Jeanie Bourke - RE: Permit No. 201502206 - 135 Walton St.

Permit No. 201502206

Project Name : 135 Walton Street

A1.01

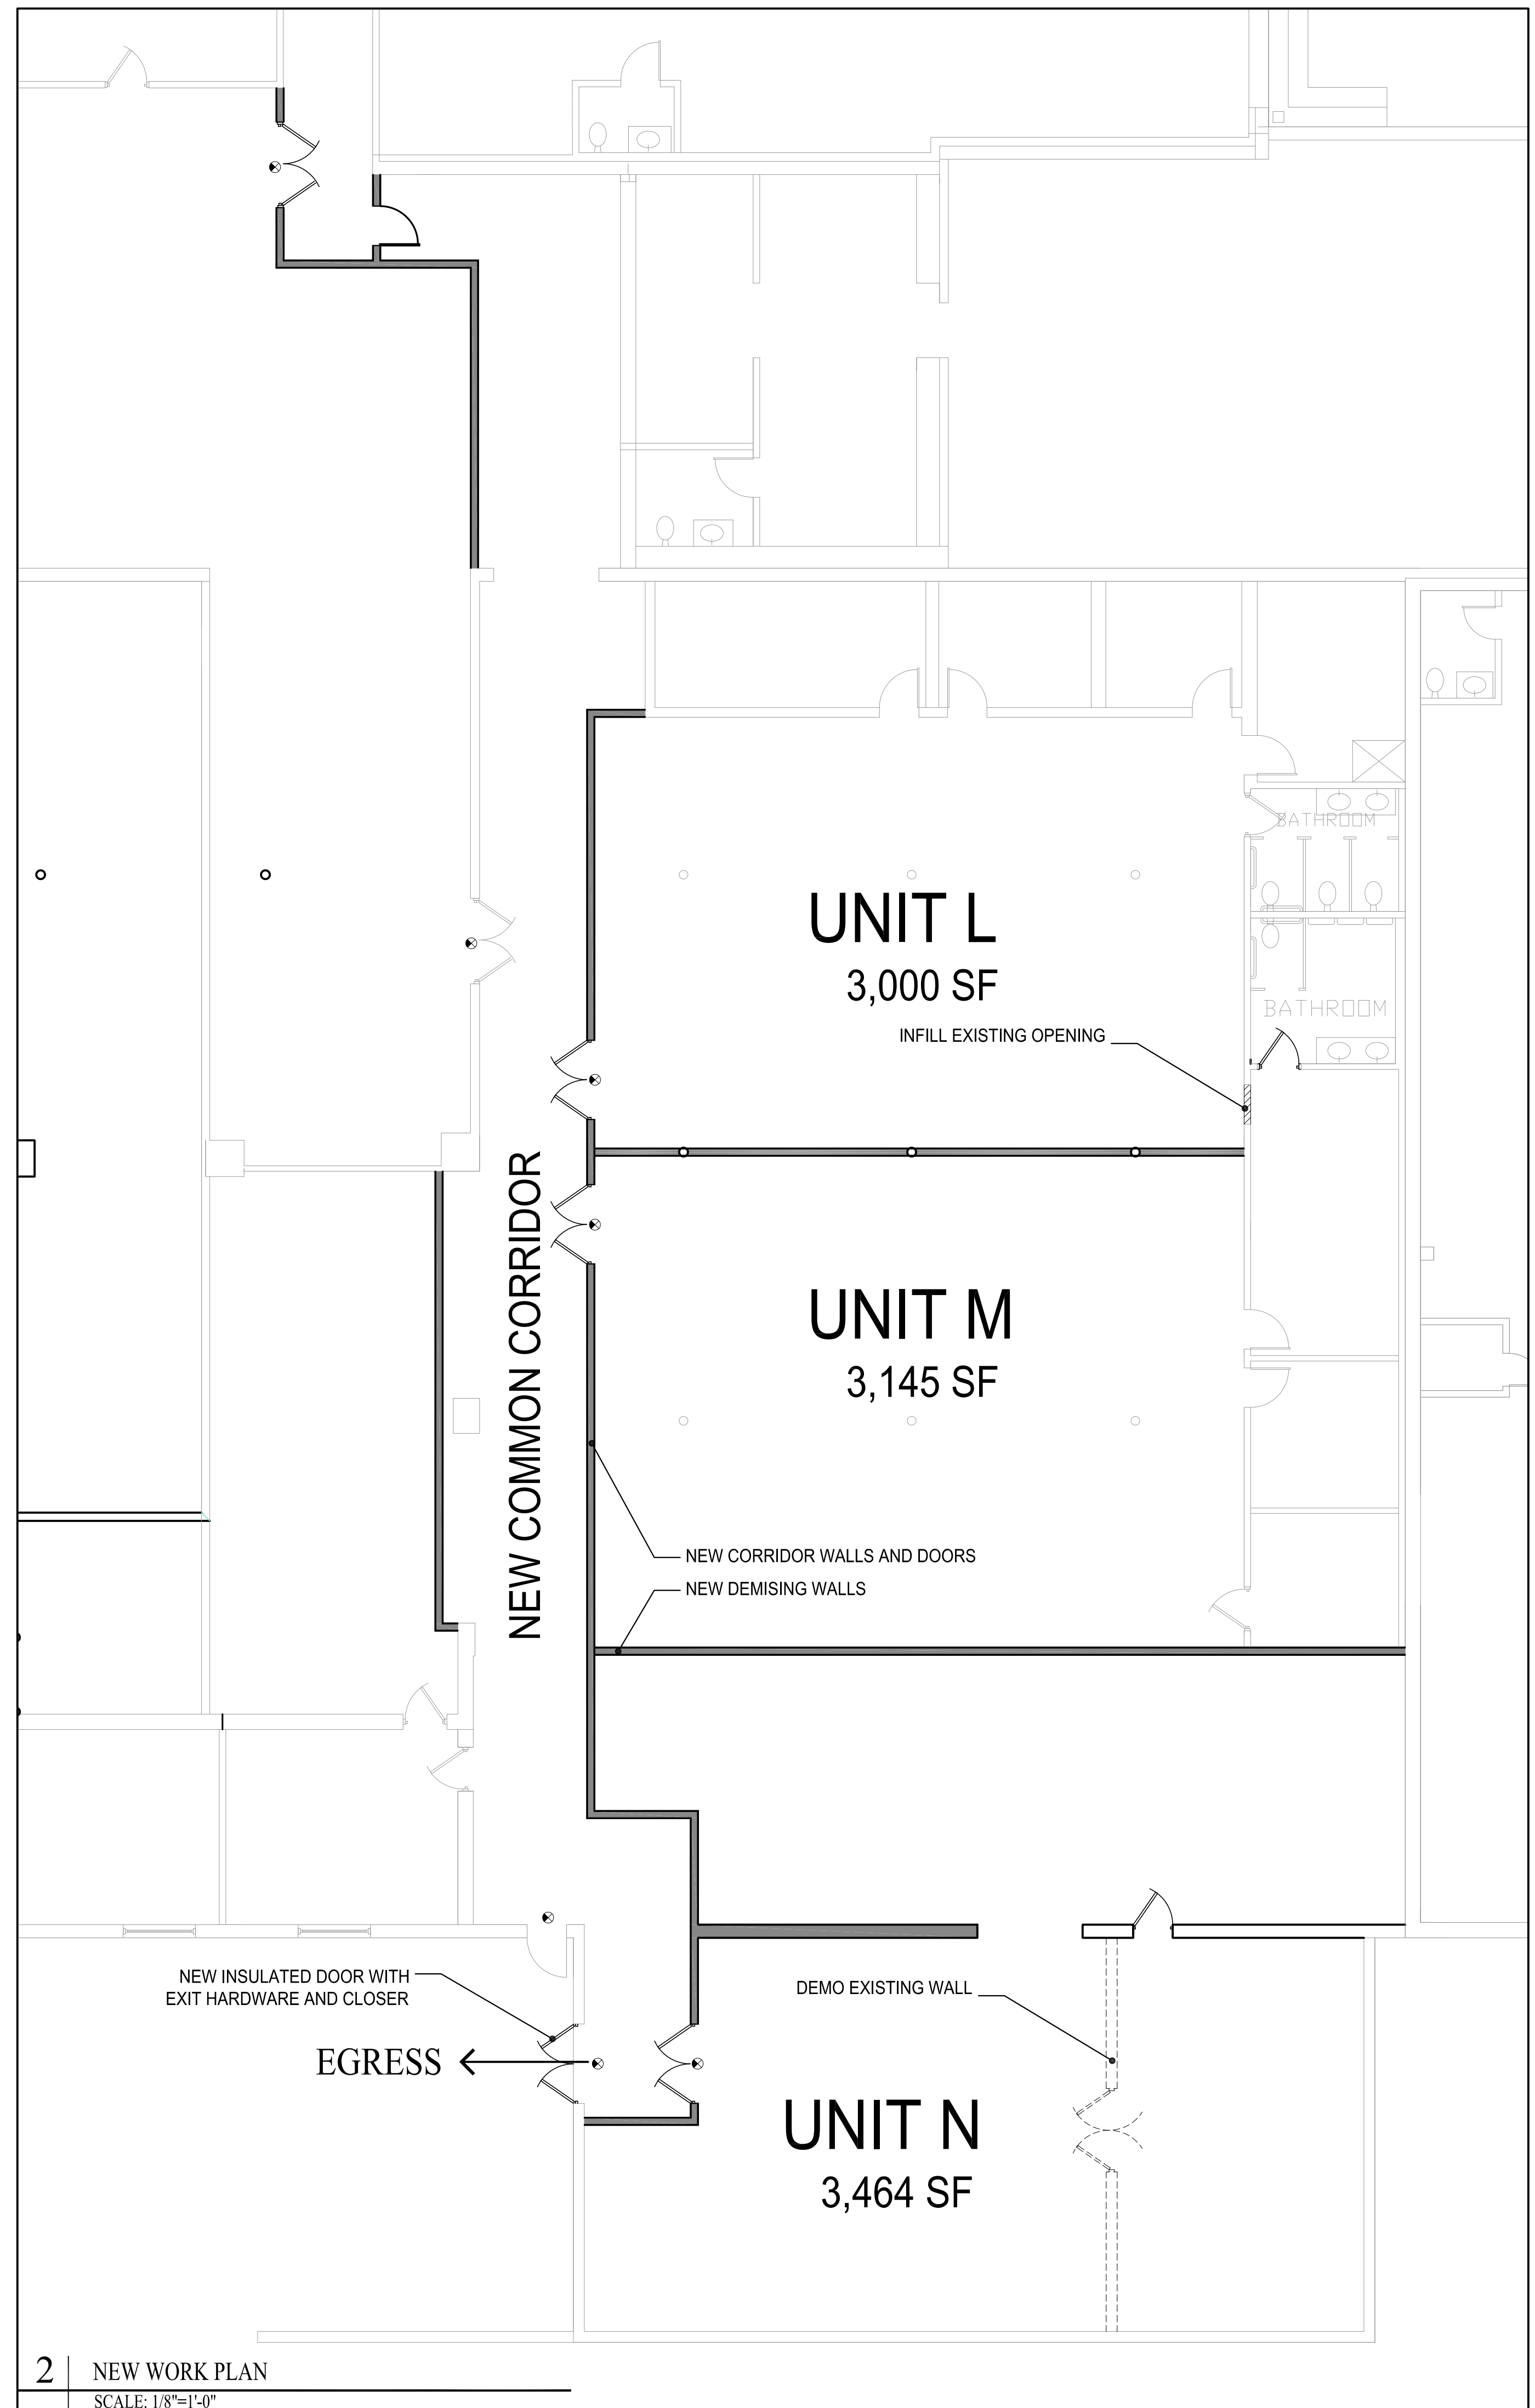
1. This new plan pdf file name and sheet is not consistent with the original, please correct and resubmit:

Original pdf - A4 Scope of Work
New pdf - 135 Walton Street - A1.01

2. The Wall Type W1 is listed as 1 hour rated. As there are no tags for W1 on the walls and infill, is the assumption that all the walls will be constructed as such, and is this a required rating? The wall description (s) should contain the head of wall detail, ie. to the underside of the roof deck, or other, and if a fire resistive joint is required.

3. At the right hand side there is an new door installed from the existing Unit H into the new Unit L, please clarify if this is rated and what purpose, ie. exit, etc.

Original pdf - A4 Scope of Work
 New pdf - 135 Walton Street - A1.01
 Attached

Per the discussion had about the project, all new wood walls are to be one hour rated, in lieu of a non-rated, non-combustible system. There is no rating required, but in order to resolve the issue of the wall types, we are providing a 1-hour rated system. (also now stated on the drawings)

3. At the right hand side there is an new door installed from the existing Unit H into the new Unit L, please clarify if this is rated and what purpose, ie. exit, etc. This door is to be a communicating door between units, which is not rate. (also now stated on the drawings)

A2

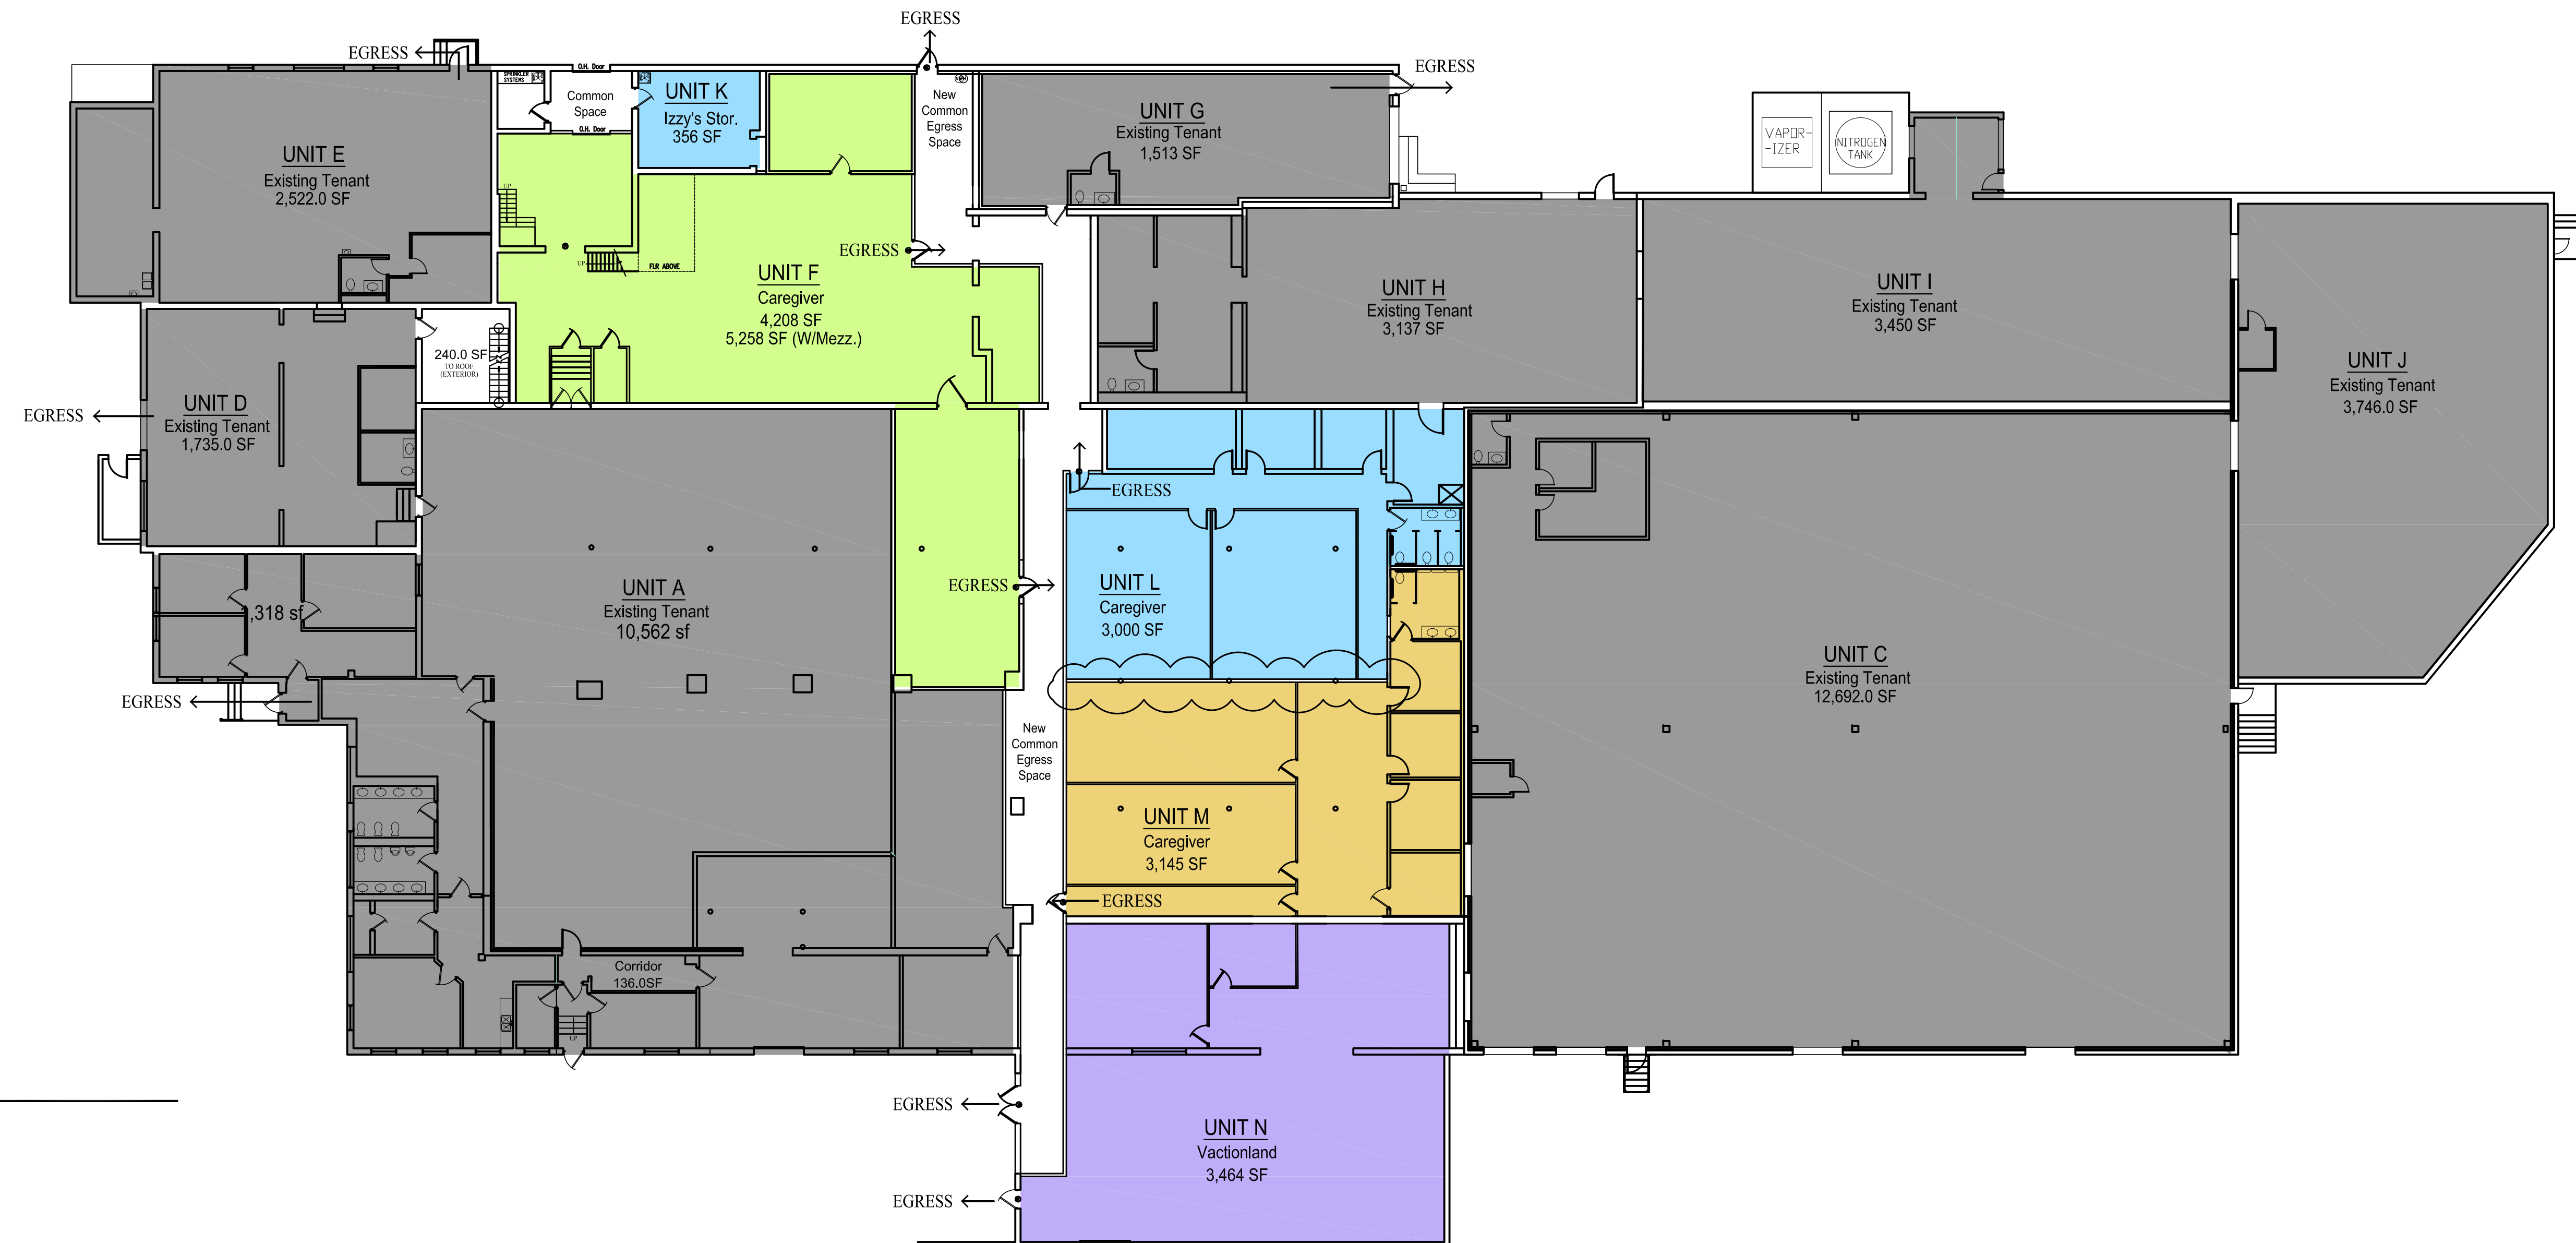
4. See the attached Key Plan with markup to be corrected at the demising wall between Unit L and Unit M.

4. See the attached Key Plan with markup to be corrected at the demising wall between Unit L and Unit M.
 Attached
